Re: **Marysville Corporate Center**
Final BSP – PA22004
Project Number 2200444.06

In response to your plan review checklist dated December 21, 2023, we have addressed the items below, with our responses following your comments.

INDEX DATA: SEC 28-33 T 31N R 5E WM
SURVEY FOR: PACIFIC REALTY ASSOCIATES, L.P. 15908 47TH AVE NE MARYSVILLE, WA 98271
SNOHOMISH COUNTY, WASHINGTON
SHEET 8 OF 13

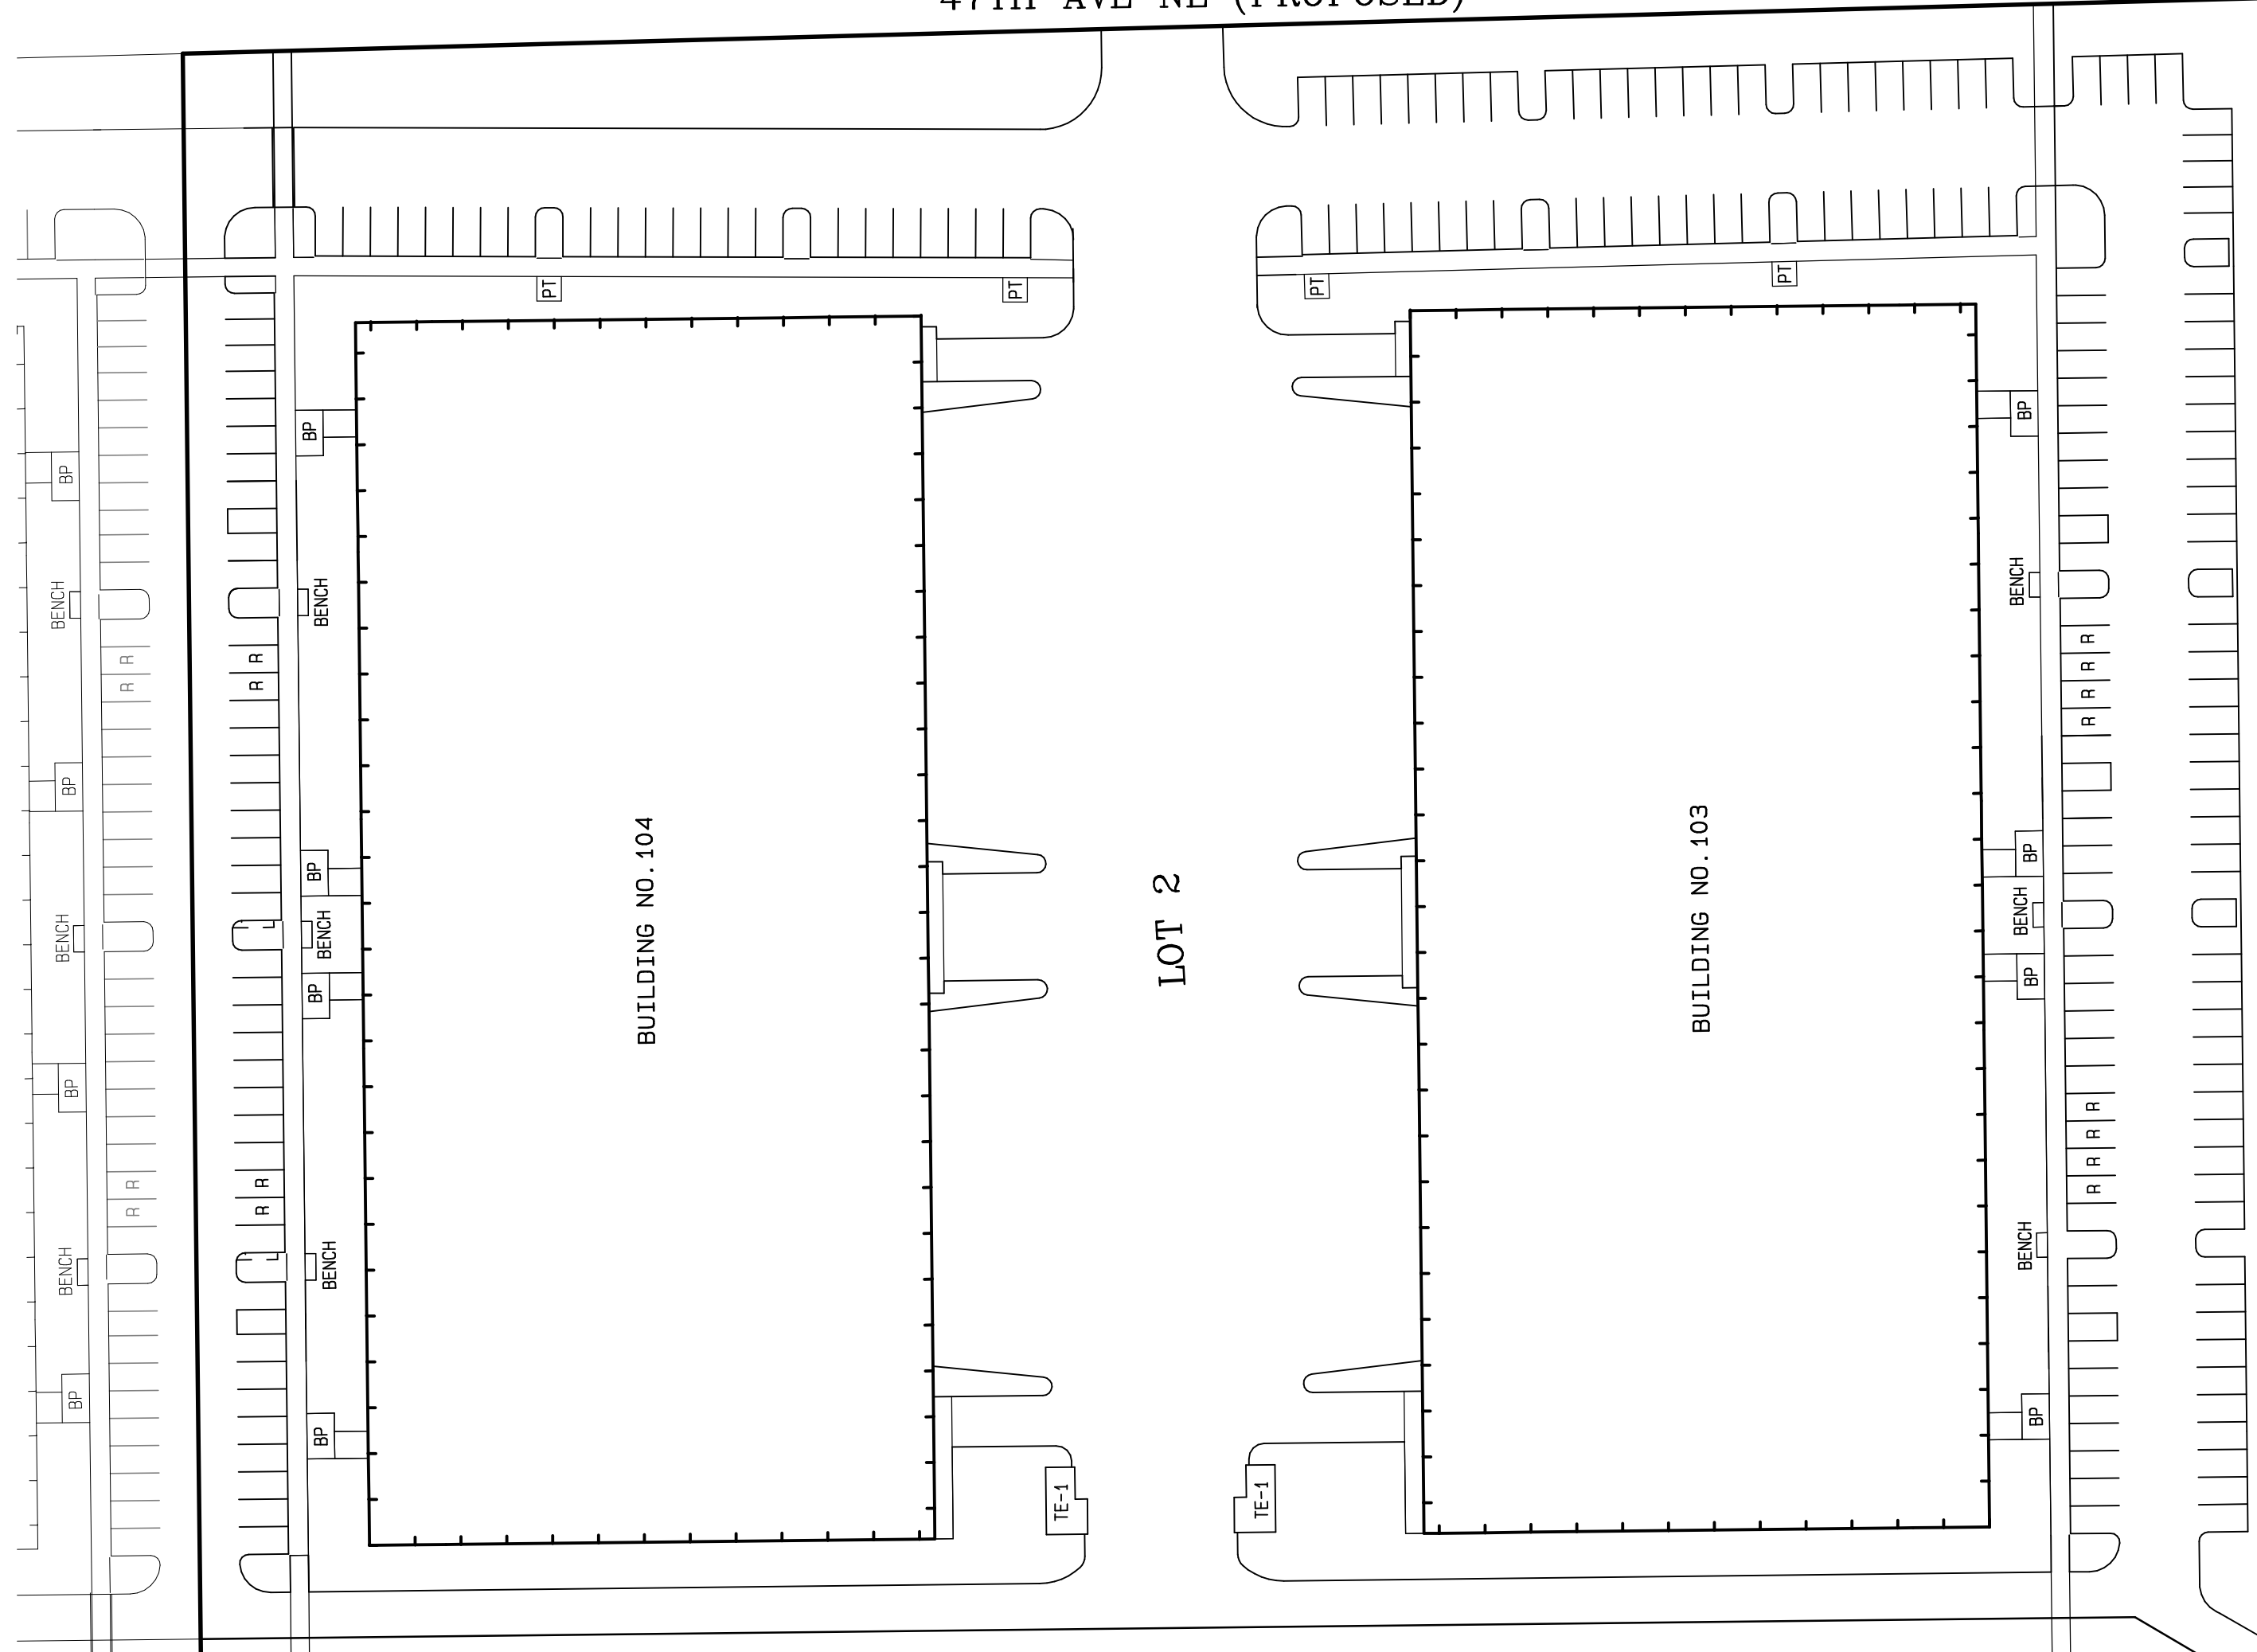
7. *Sheet 8 of 13:*
- a. Remove 156TH ST NE (~~PROPOSED~~), and amend to read "156TH ST NE (HEREBY DEDICATED PUBLIC RIGHT OF WAY)".
 - b. Remove 47TH AVE NE (~~PROPOSED~~), and amend to read "47TH AVE NE (HEREBY DEDICATED PUBLIC RIGHT OF WAY)".
 - c. Remove reference to parking stall dimensions.

Response: All requested text has been added, removed, and amended.

INDEX DATA: <b>SEC 28-33 T 31N R 5E WM</b>
SURVEY FOR: PACIFIC REALTY ASSOCIATES, L.P. 15908 47TH AVE NE MARYSVILLE, WA 98271
<b>SNOHOMISH COUNTY, WASHINGTON</b>
<b>SHEET 9 OF 13</b>

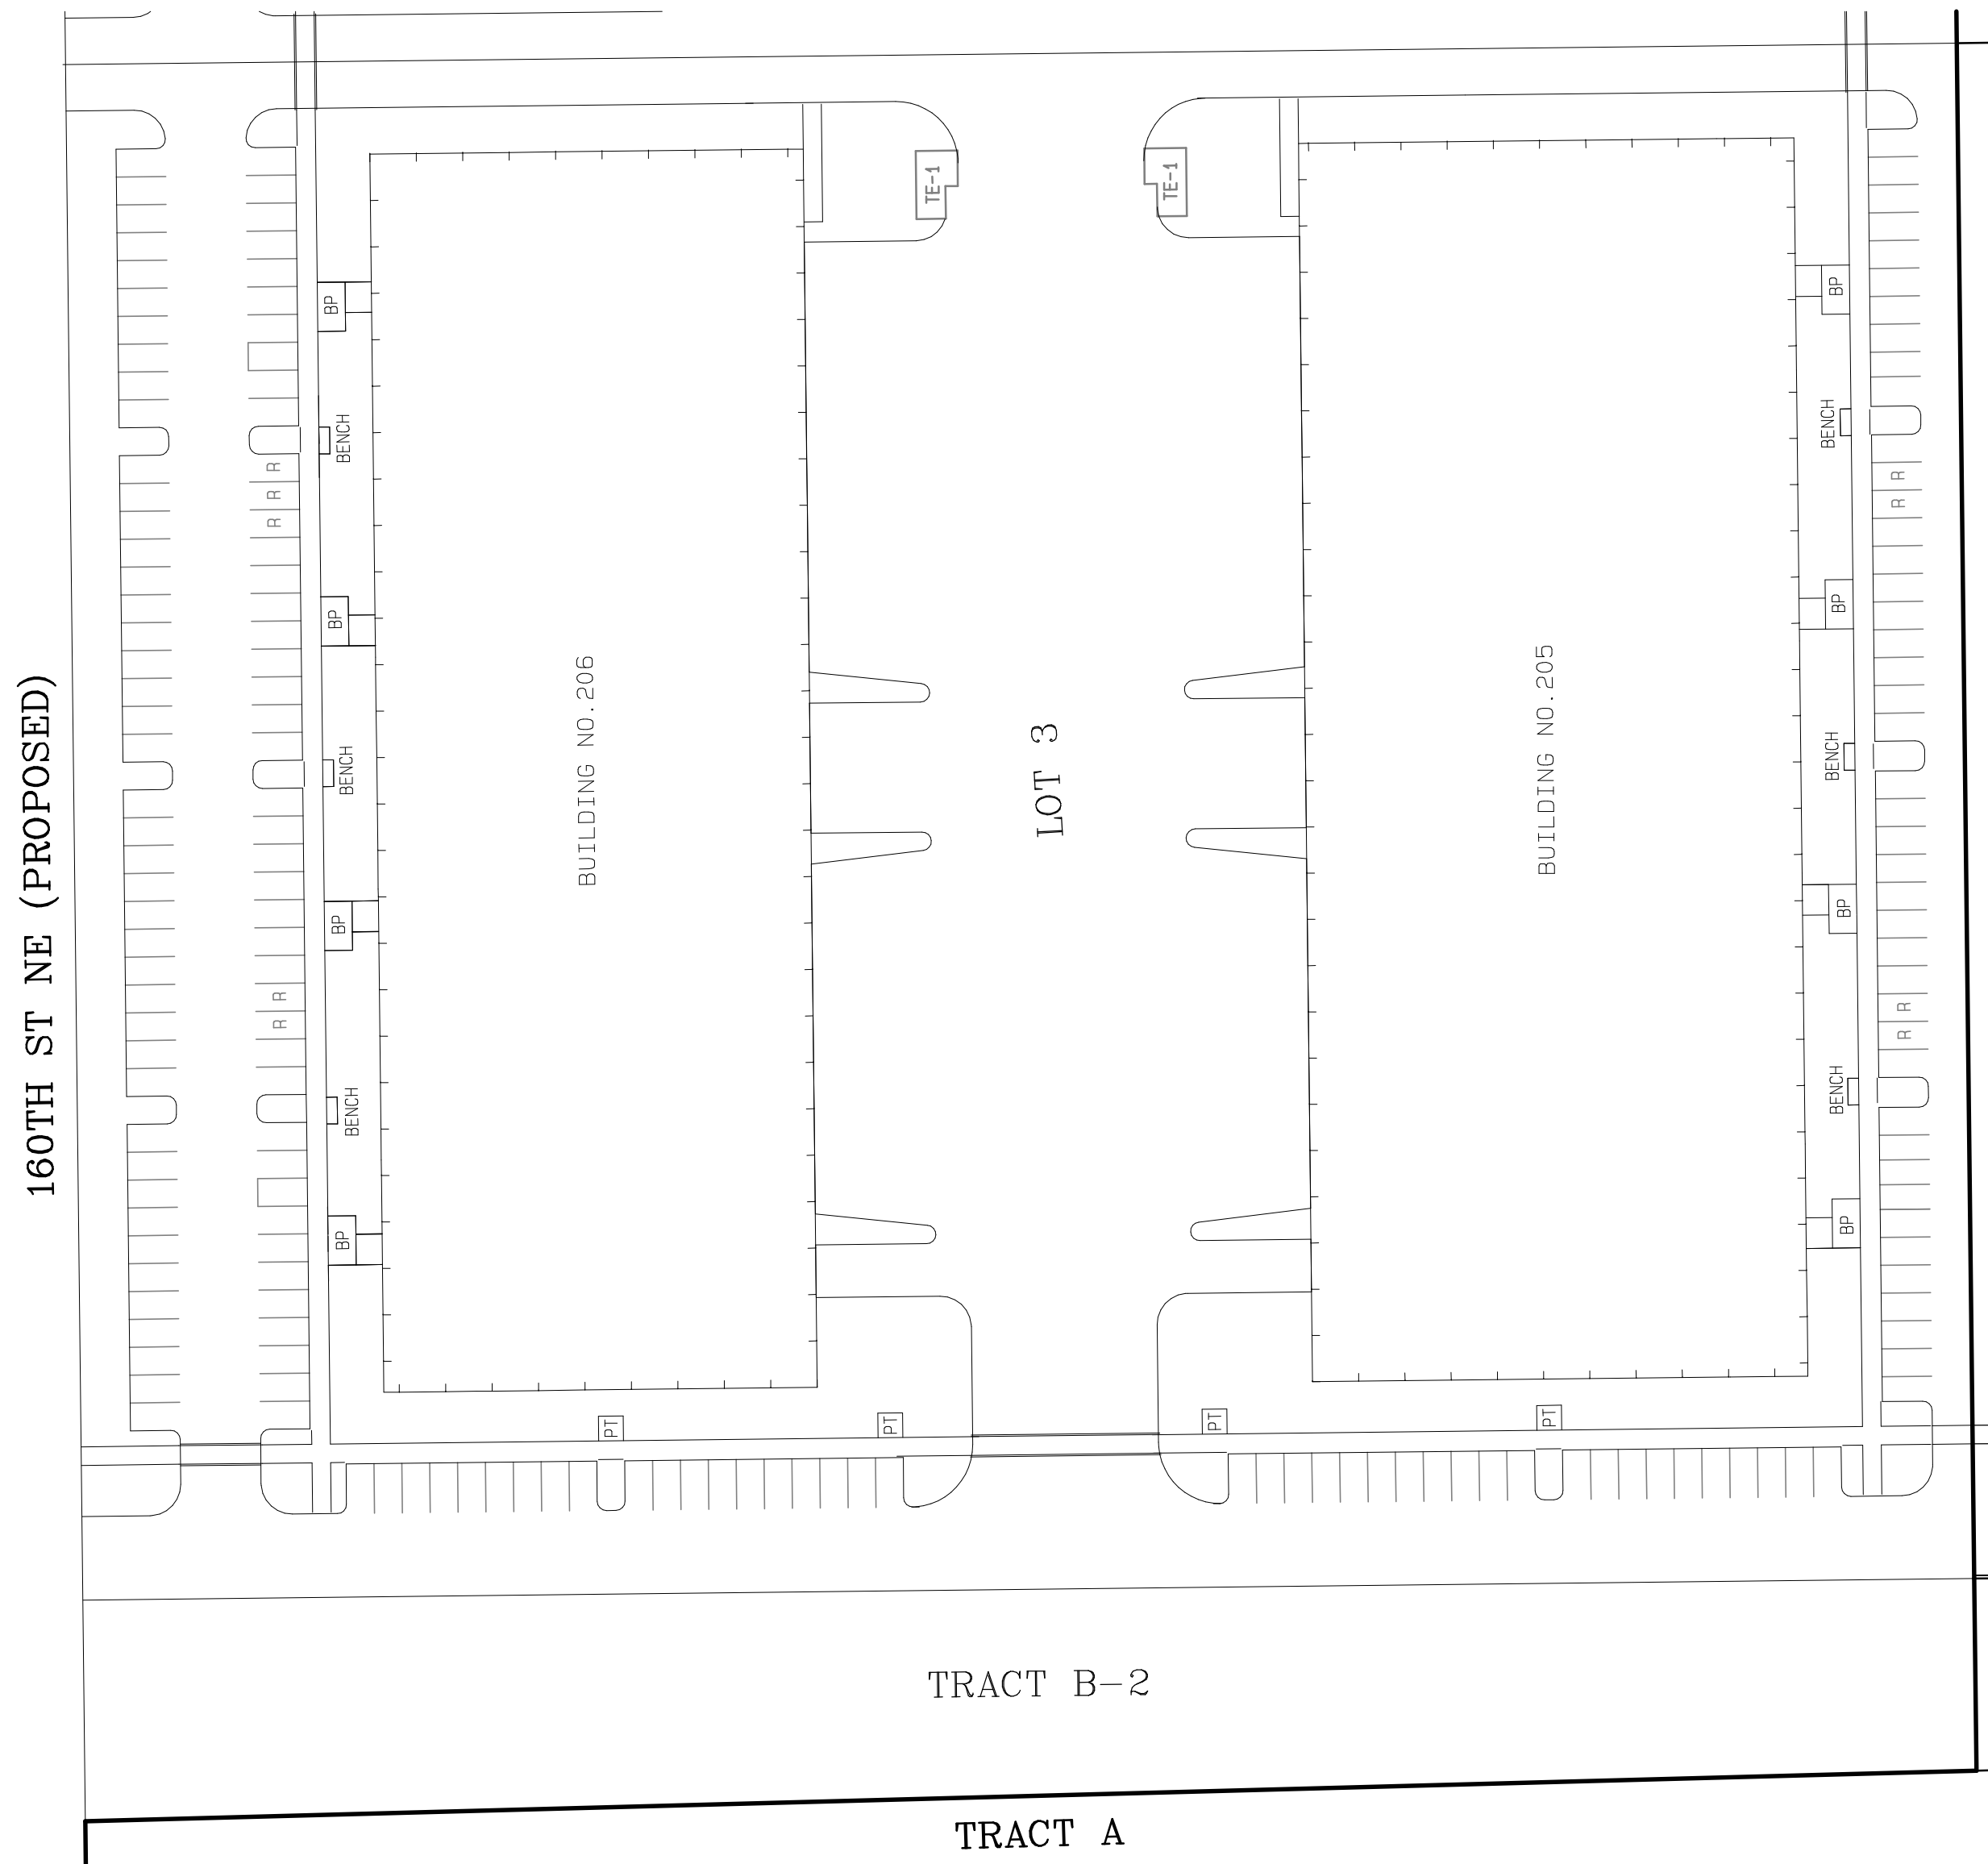
8. *Sheet 9 of 13:*
- a. Remove 156TH ST NE (~~PROPOSED~~), and amend to read "156TH ST NE (HEREBY DEDICATED PUBLIC RIGHT OF WAY)".
 - b. Remove reference to parking stall dimensions.

Response: All requested text has been added, removed, and amended.
